WEST SUSSEX COUNTY COUNCIL CONSULTATION

TO:	Arun District Council FAO: Anita Gardner
FROM:	WSCC - Highways Authority
DATE:	25 May 2021
LOCATION:	Flintacre, Toddington Lane, Littlehampton, BN17 7PN
SUBJECT:	LU/146/21/OUT Outline application with some matters reserved (appearance & landscaping) for 1 No detached dwelling. This application may affect the setting of a listed building.
DATE OF SITE VISIT:	N/A
RECOMMENDATION:	Advice
S106 CONTRIBUTION TOTAL:	N/A

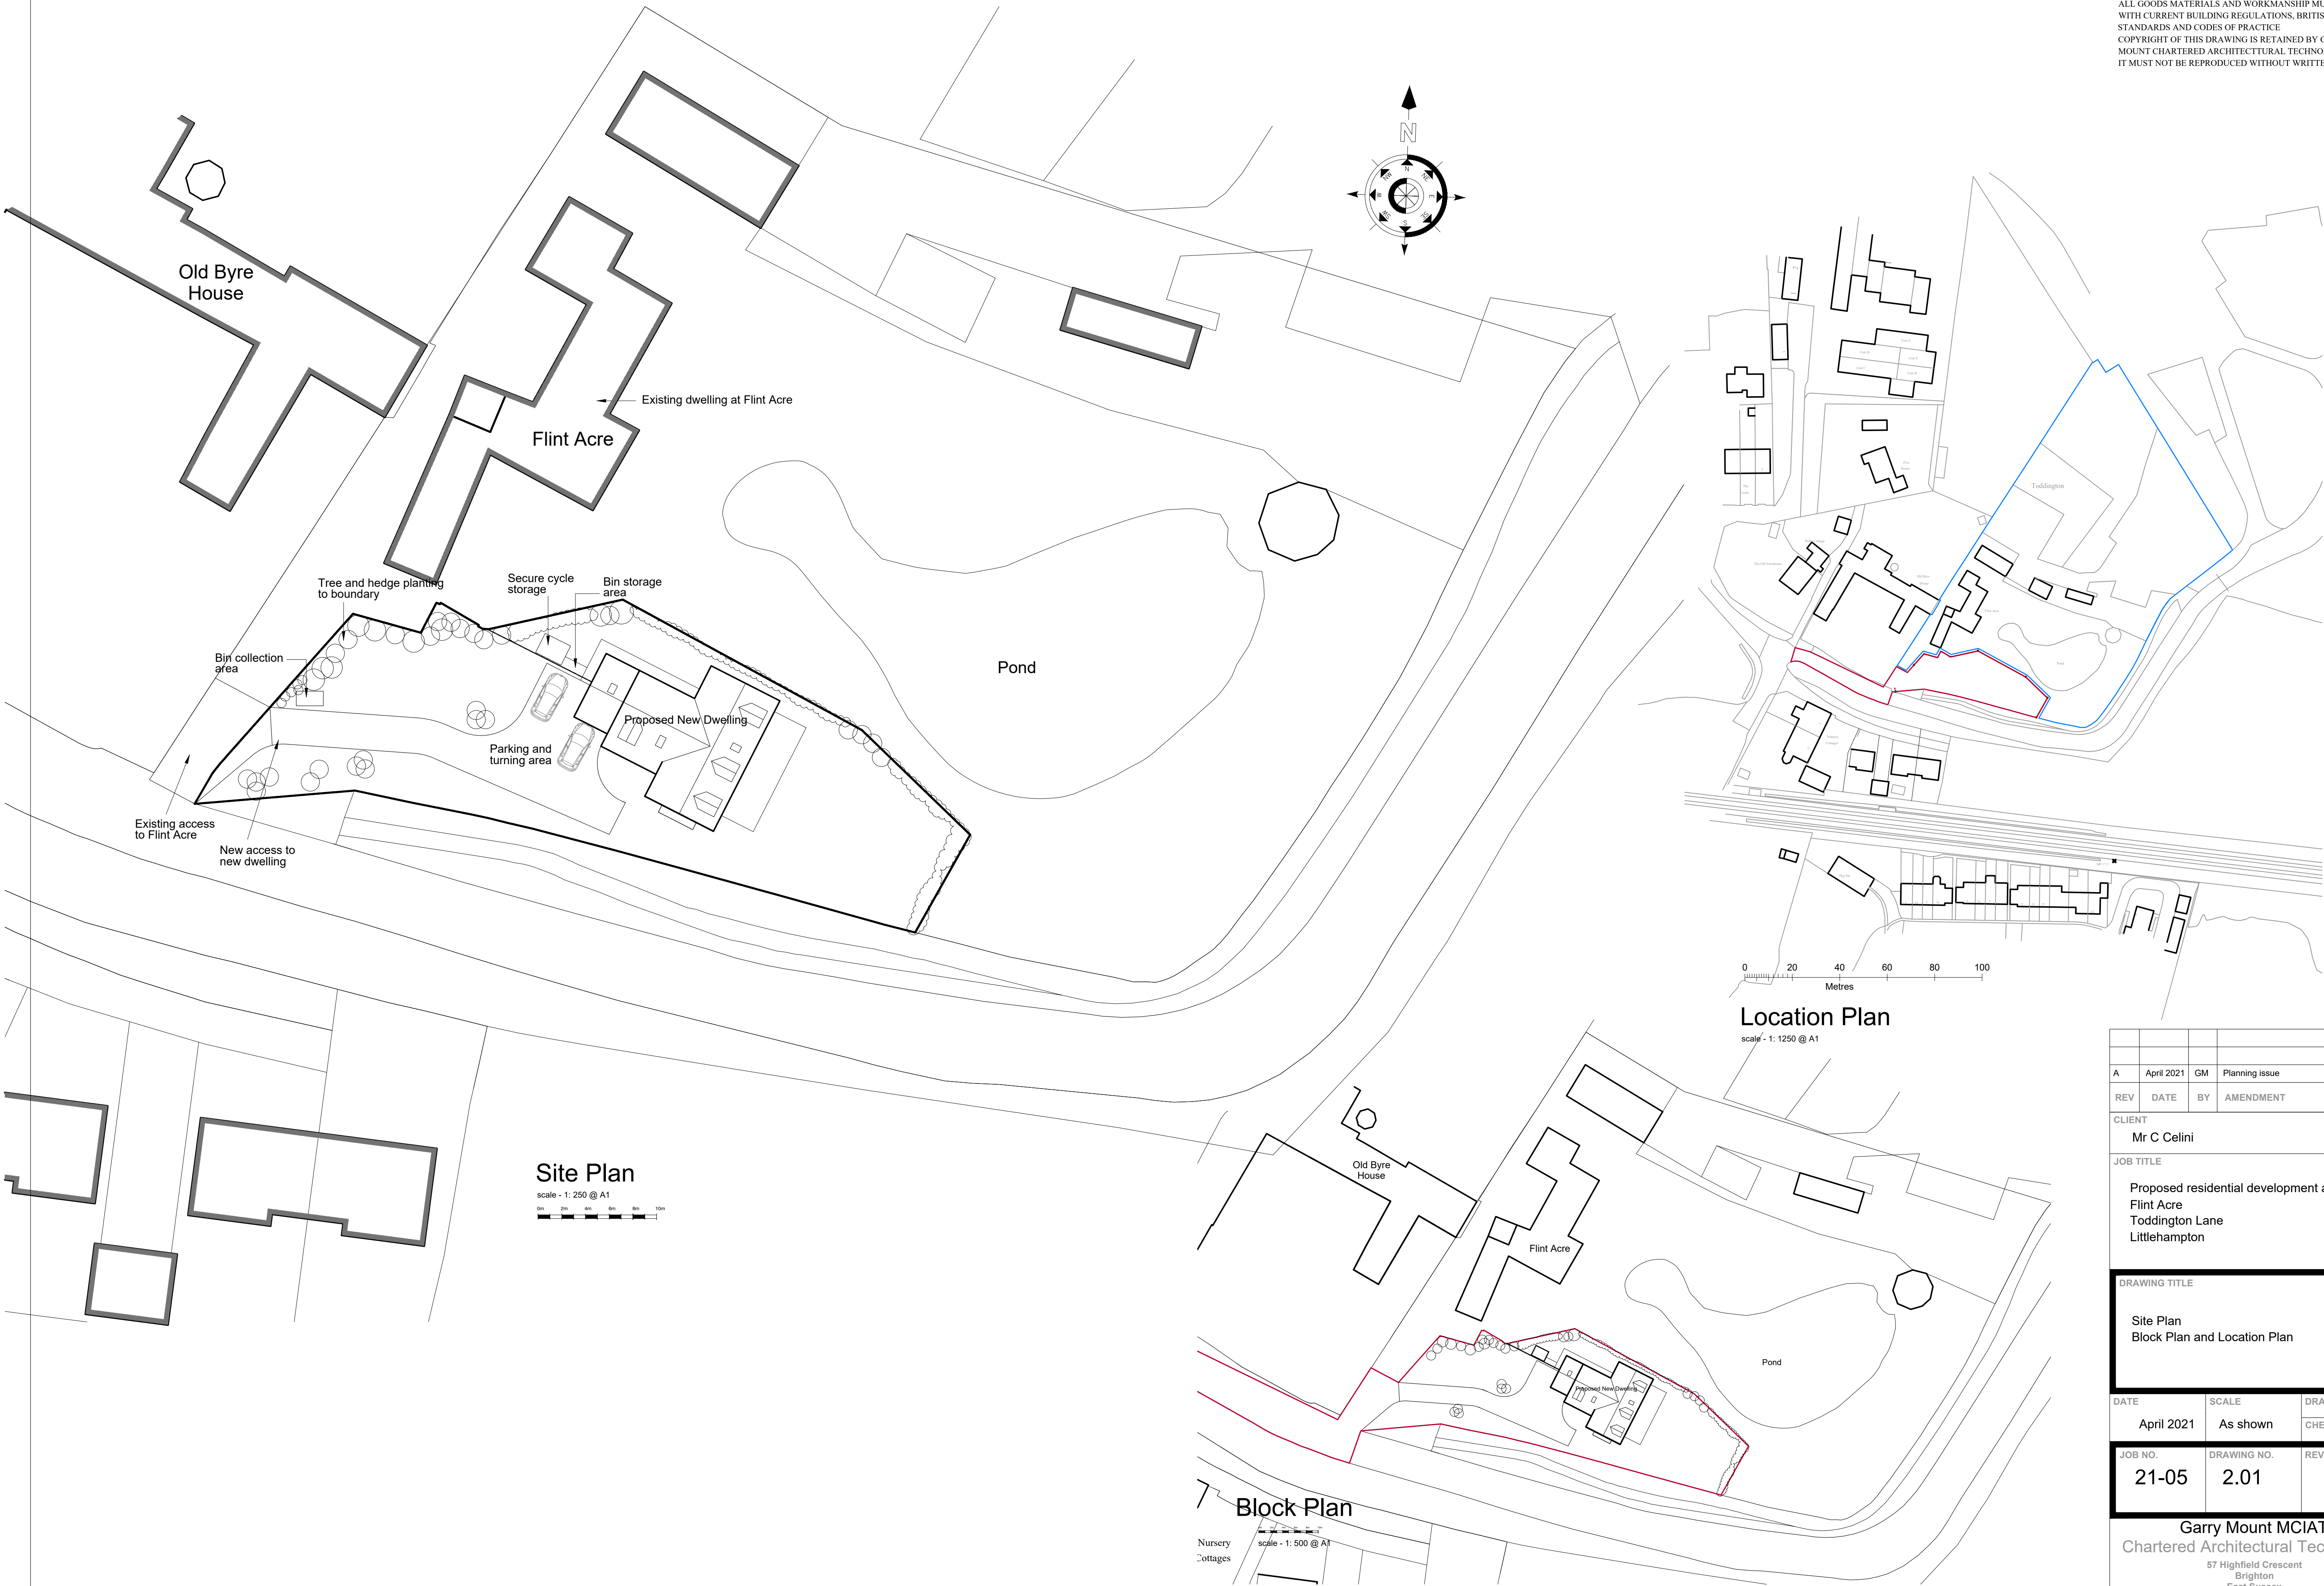
The applicant proposes to utilise the existing vehicular access off Public Footpath no. 3096, to form a shared access. From inspection of local mapping, there are no apparent visibility issues with the existing accesses onto the PROW or Toddington Lane. In addition, the LHA does not anticipate that the proposal would give rise to a significant material intensification of movements using these accesses.

The applicant proposes three car parking spaces for this development, in the form of a single-car garage and driveway with two parking spaces. Under Arun Parking Standards, the LHA would expect a dwelling of this size in this location to provide at least two car parking spaces. Therefore, the LHA considers the proposed parking provision to be sufficient. In addition, the applicant has demonstrated a turning head, which will allow cars to turn and exit the site in a forward gear.

DRAWING TITLE
Indicative Plans and Elevation

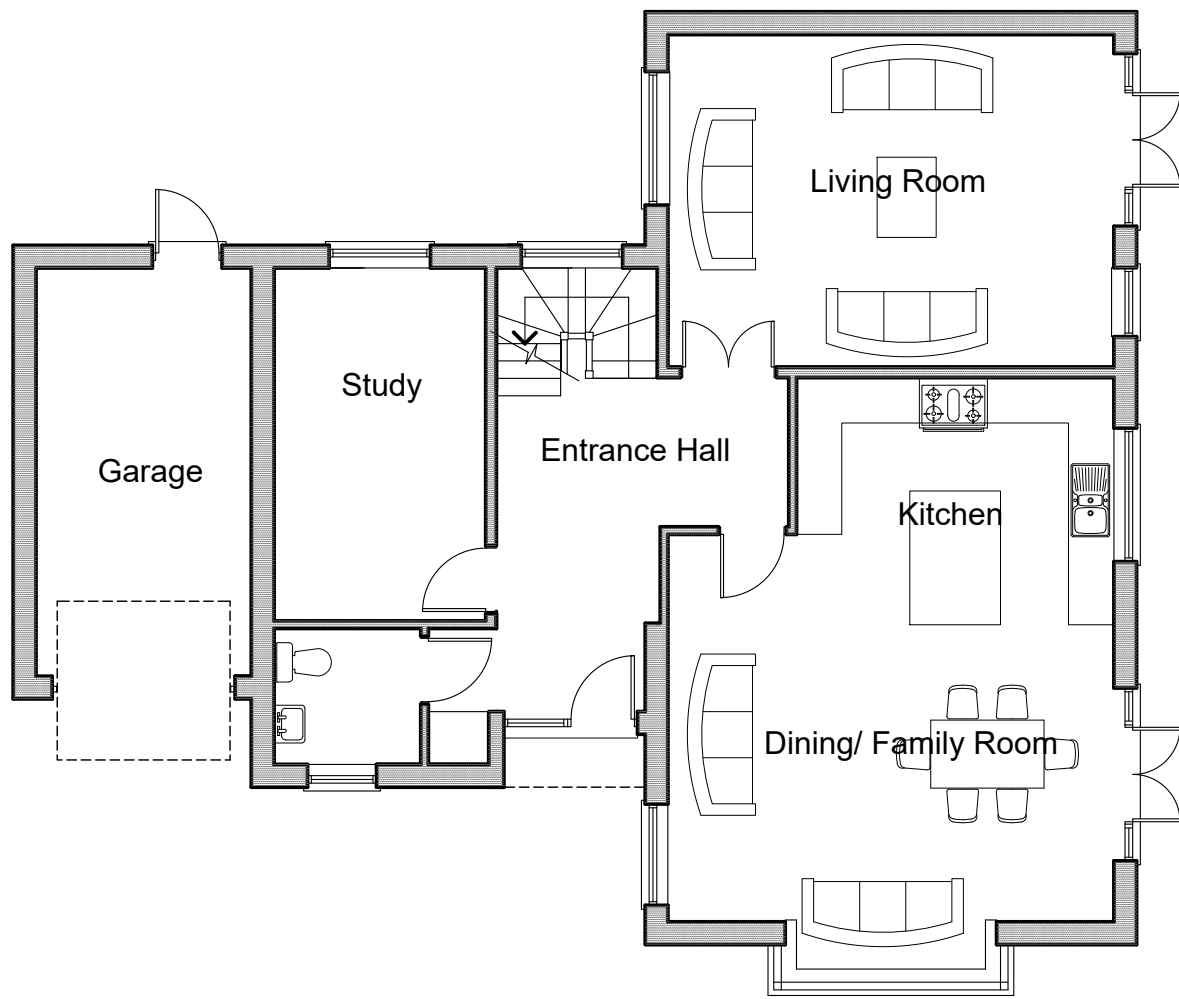
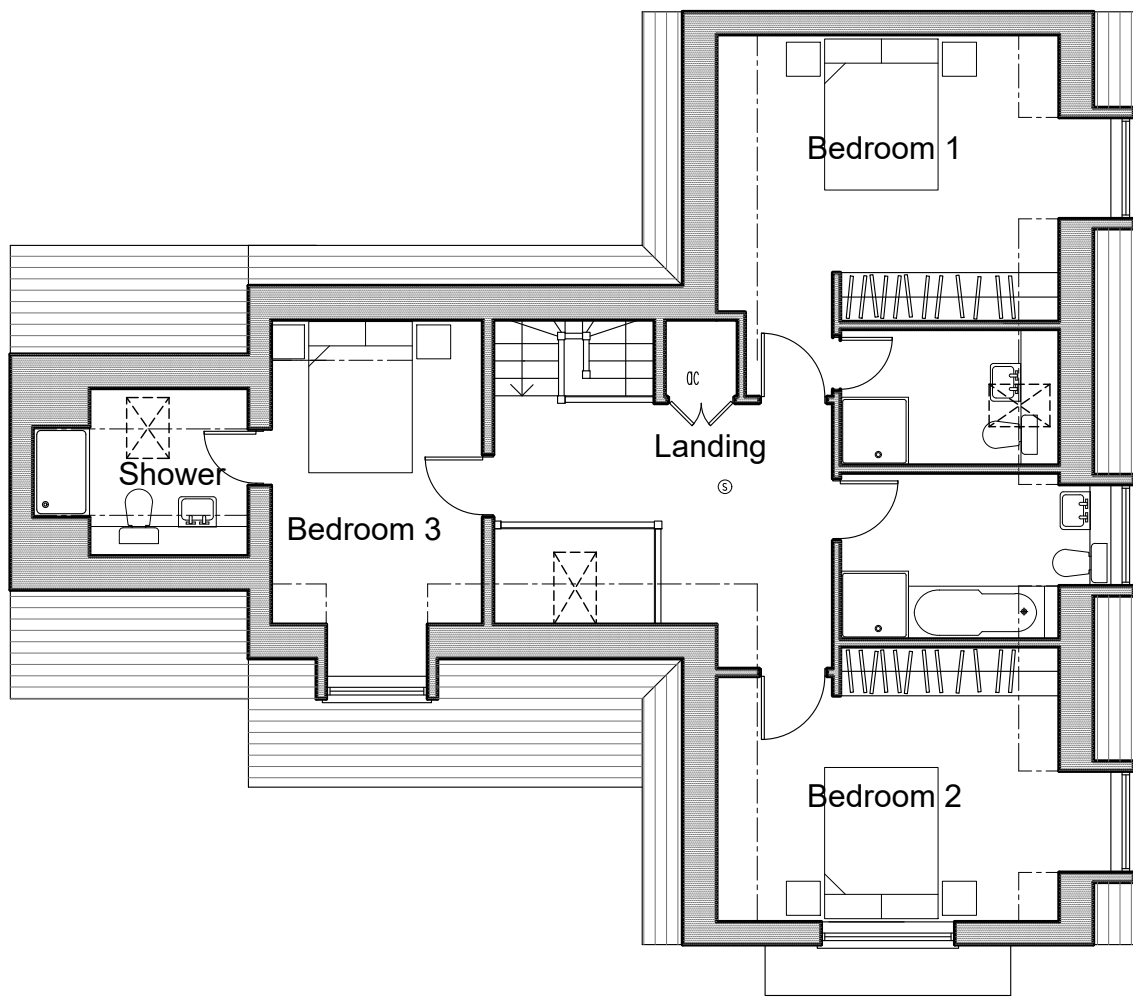
The LHA notes that the proposed garage falls short of the minimum internal specifications for single-car garages of 3m x 6m as set out in Manual for Streets (MfS). The garage as proposed has approximate internal dimensions of 2.85m x 5.4m. Therefore, the LHA advises the applicant to

enlarge the garage to meet MfS specifications, to be considered for vehicular parking provision. Notwithstanding this, the LHA is satisfied that adequate parking is available on-site.
